RE: P20/06621/F; ERECTION OF 5NO. DWELLINGS WITH ASSOCIATED ACCESS, PARKING AND LANDSCAPING

We wish to make a S73-Application in relation to the above approved scheme, to alter the entrance point off Tabernacle Road into the site, by means of a reduction in width.

DRAWING NUMBER	REV.
1023-008	C

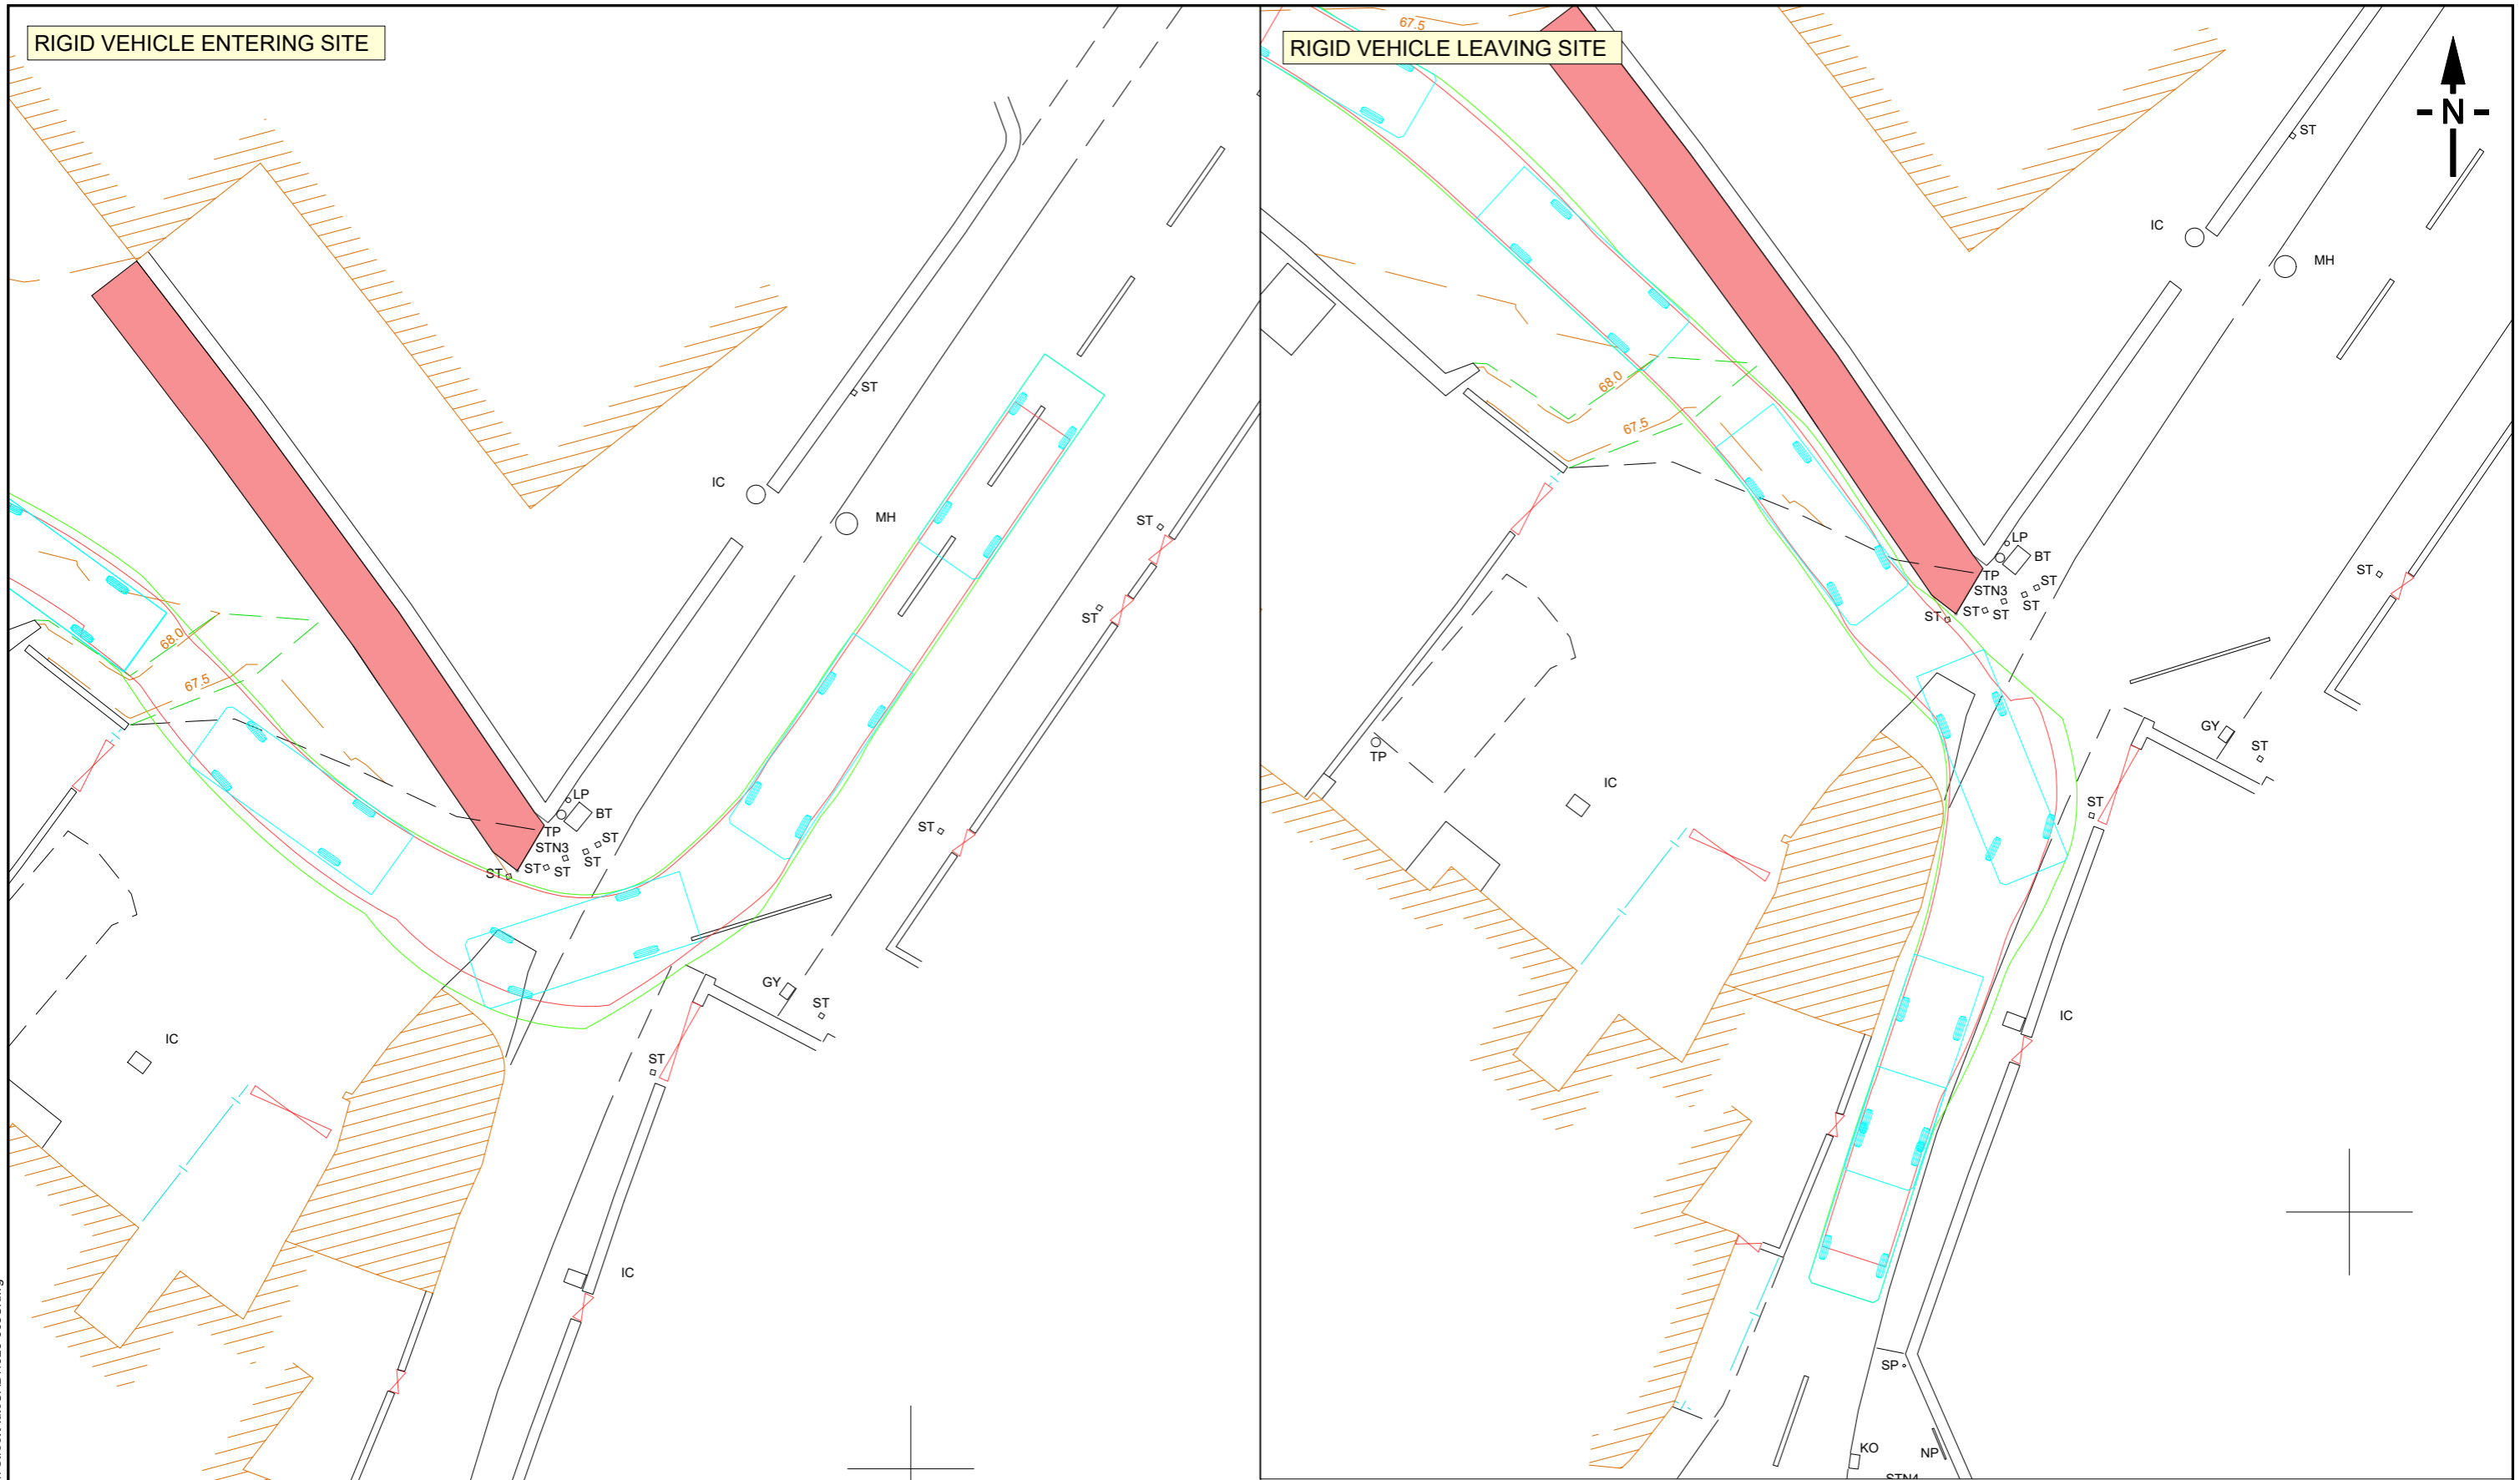
3. There are two drawings enclosed with this application from Key Transport Consultants for reference to the turning manoeuvres required which ultimately indicate that whilst tight, a rigid axle vehicle (7.5tn) can enter and exit the site through this reduced opening width. Therefore, concluding that there were no transportation concerns to the revised access arrangement proposed, because of changes made to the Red Line Boundary.
The first, drawing 1023-003, indicates the movements as originally submitted with the approved scheme.
The second drawing, 1023-008 Rev C, indicates the vehicle turning without crossing the land under dispute (red hatched land).
